From: Liz Annalls [REDACTED]
Sent: 04 December 2019 10:24
To: Anita Gardner <Anita.Gardner@arun.gov.uk>
Subject: RE: CM/45/19/PL - Ryebank Farmhouse, New Barn, Climping

Subject: CM/45/19/PL - Ryebank Farmhouse, New Barn, Climping

| Rev.                                                                                                                                                                                                                                                           | Notes             | Date     |
|----------------------------------------------------------------------------------------------------------------------------------------------------------------------------------------------------------------------------------------------------------------|-------------------|----------|
| Drawing No.<br>P02 - P3                                                                                                                                                                                                                                        |                   |          |

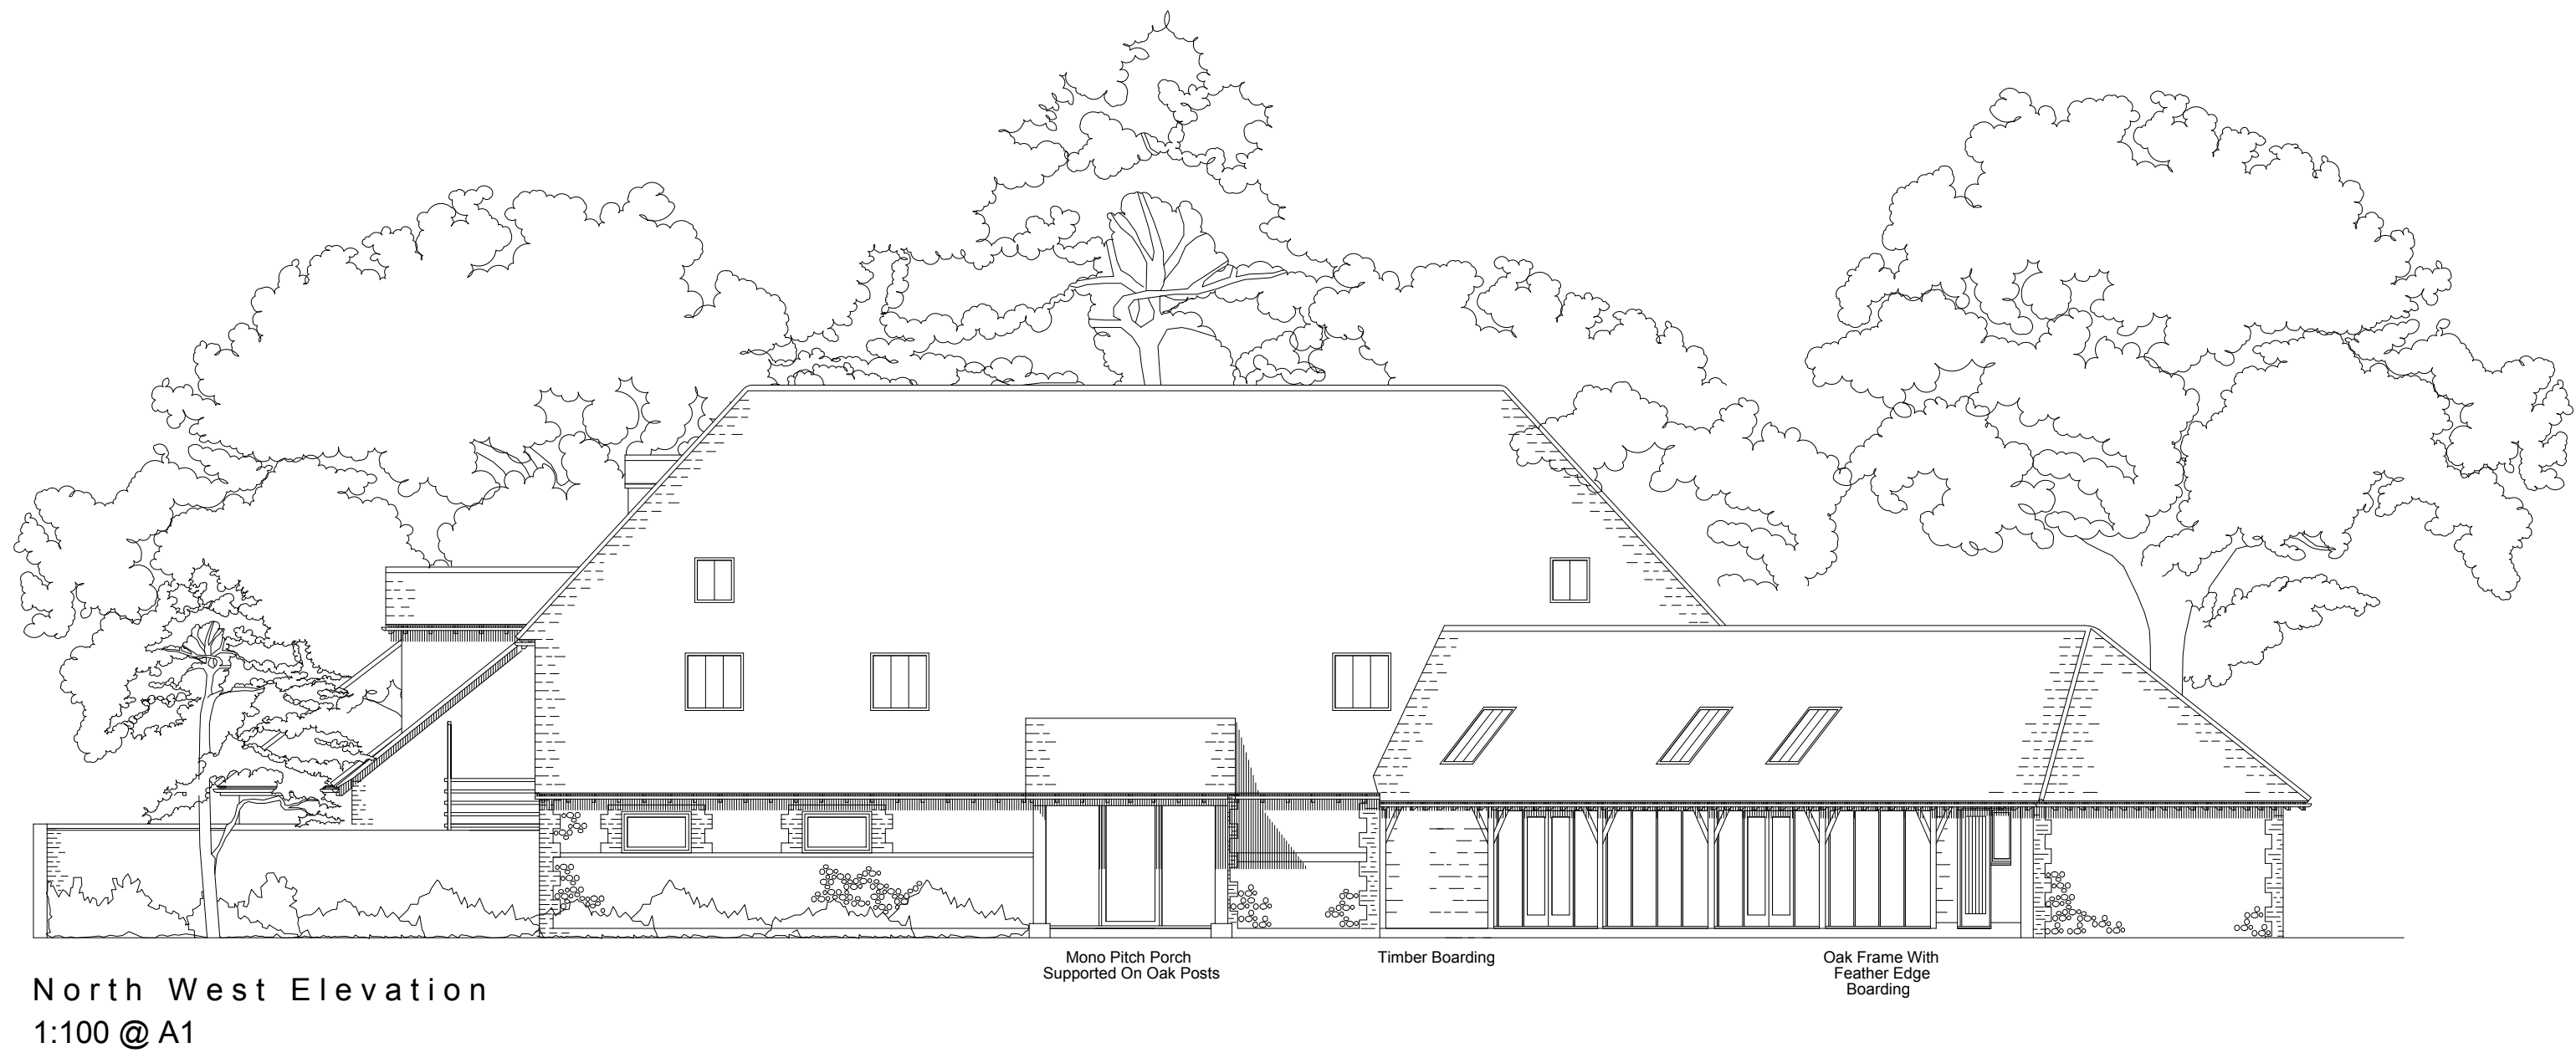
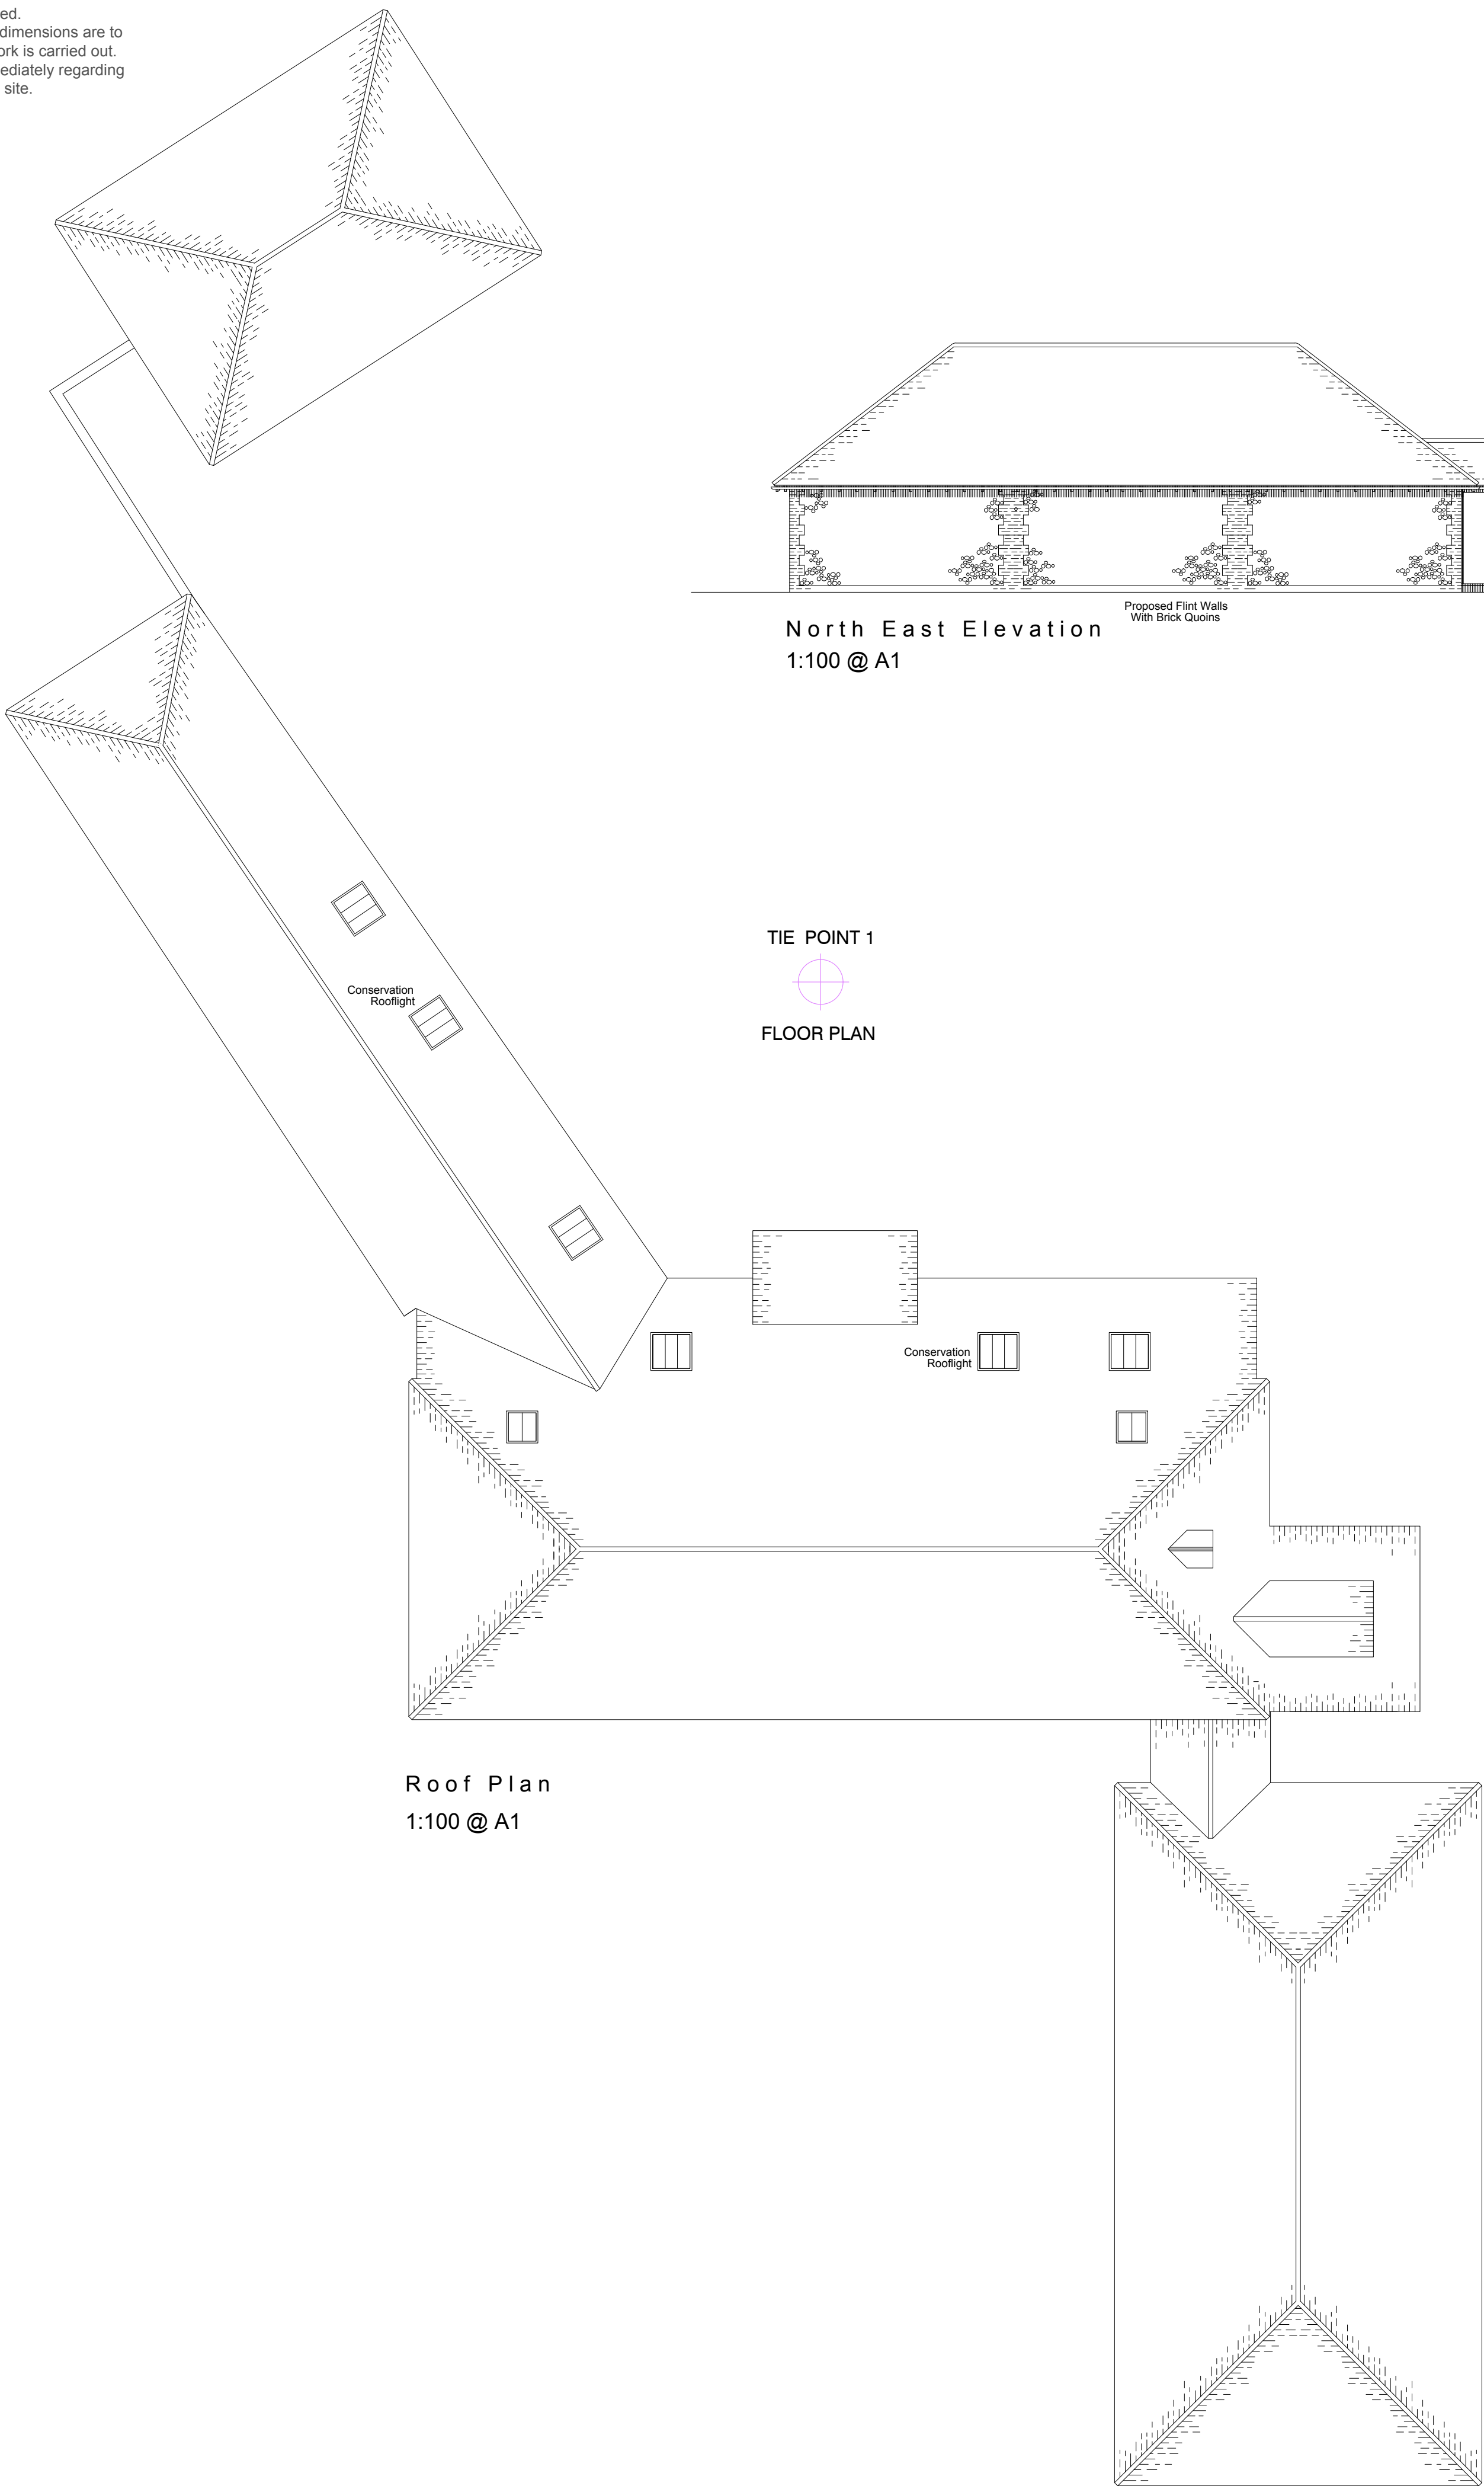
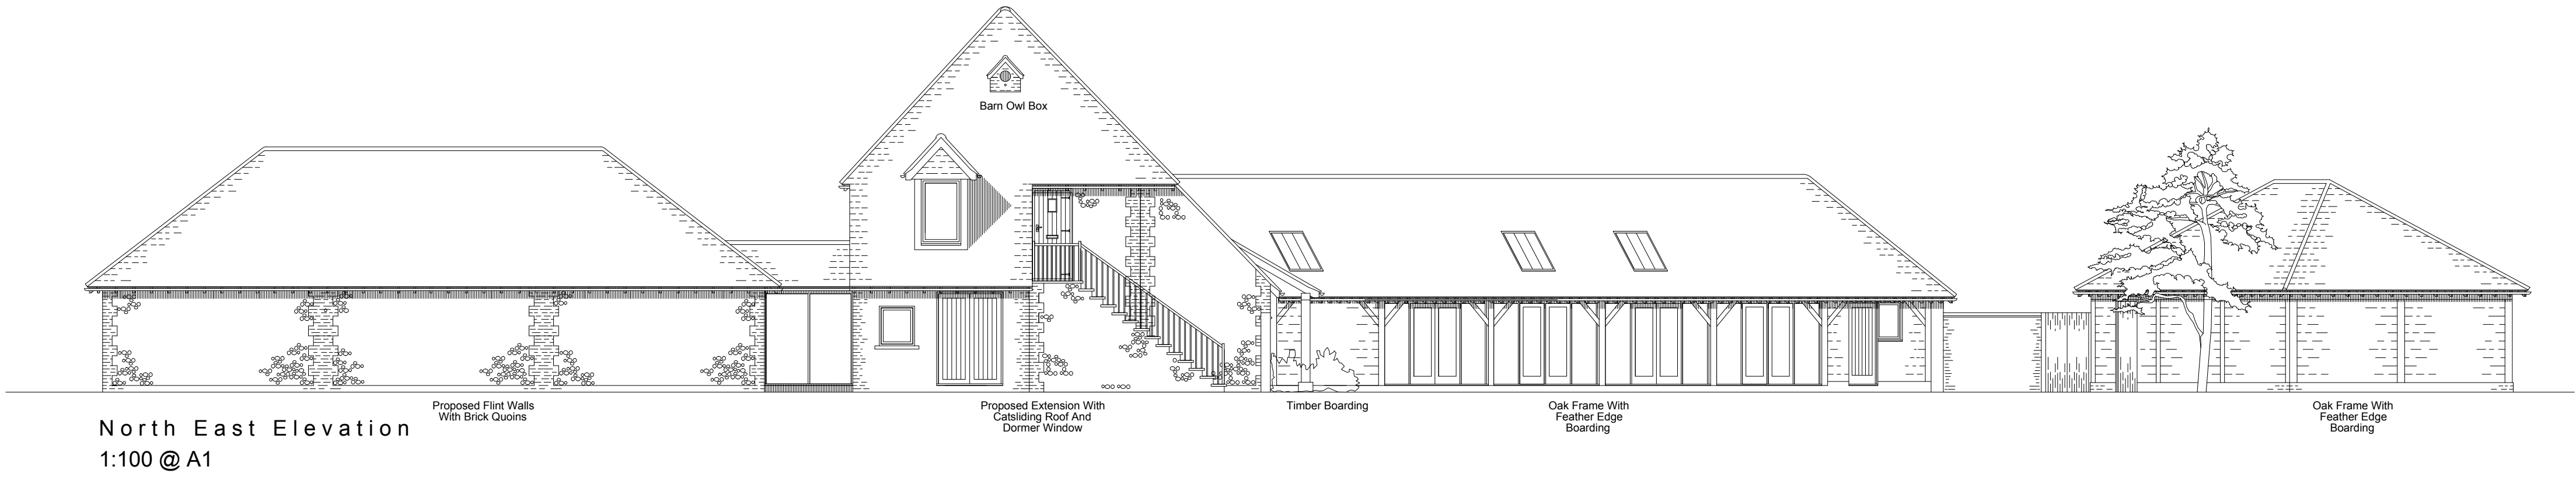
Dear Liz,
Are you happy with the position of the bat box on the North East elevation?
Thanks

Yes that is fine.
